1.1.1 This document is produced by Newett Homes and is an addendum to the Design and Access Statement (ref: DAS01 revC) originally submitted in July 2020.

1.1.2 This addendum provides an update to the design proposals following further engagement with Barnsley Metropolitan Borough Council ("BMBC").

2.8.2 Through a collaborative design process and positive engagement with the local authority, Newett Homes have revised their original design proposals and are submitting a proposal for residential development of 28 units on land off Smithy Avenue, Thurlstone.

Scale @ A3	1:100	Date	18/03/21
Drawn	JL	Checked	
Drawing No.	TS-A3.06	Rev.

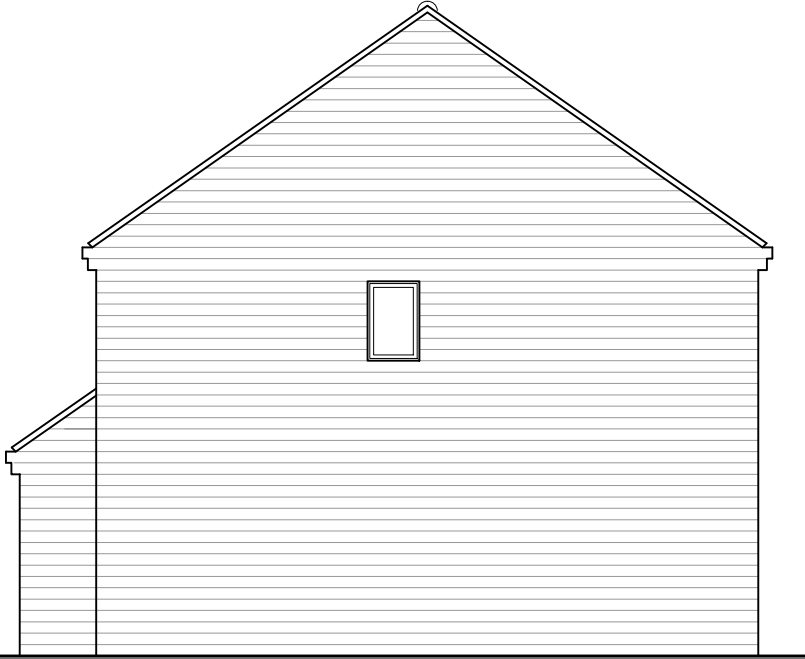
- Reduction in unit numbers.
- Key design principles from the outline scheme should be considered e.g. the kink in the road.
- One storey or one and a half storeys should be considered.
- The garages on Plots 21 and 22 should either be removed or integrated into the units.
- Hedge planting along the southern boundary should be set in to ensure there is no loss of light for the dwellings on High Bank.
- More trees and soft landscaping features required throughout to break up the built form, particularly at the site entrance.
- Additional detailing on elevations to improve their appearance and to complement the adjacent conservation area.

6. Layout has been revised to ensure protect the residential amenity of the existing properties along the southern boundary/High Bank. The area around plots 9-10 (formerly plots 20-23) have been re-designed to reduce the distance between the proposed dwellings and the adjacent properties on High Bank through the removal of 2 dwellings and the provision of public open space ("POS"). This acts as a buffer between the proposed development and properties on High Bank and will be accessible to all residents (existing and future). The POS will be naturally overlooked by the plots 9-10 which are dual fronted and by the existing properties on High Bank.

7. Garages for plots 9-10 moved further north away from existing properties on High Bank to protect their residential amenity.
8. A 1500mm high hit and miss fence with a 300mm trellis on top is proposed around plots 9-10 to help delineate public and private space and to help maintain the privacy for those particularly plots.
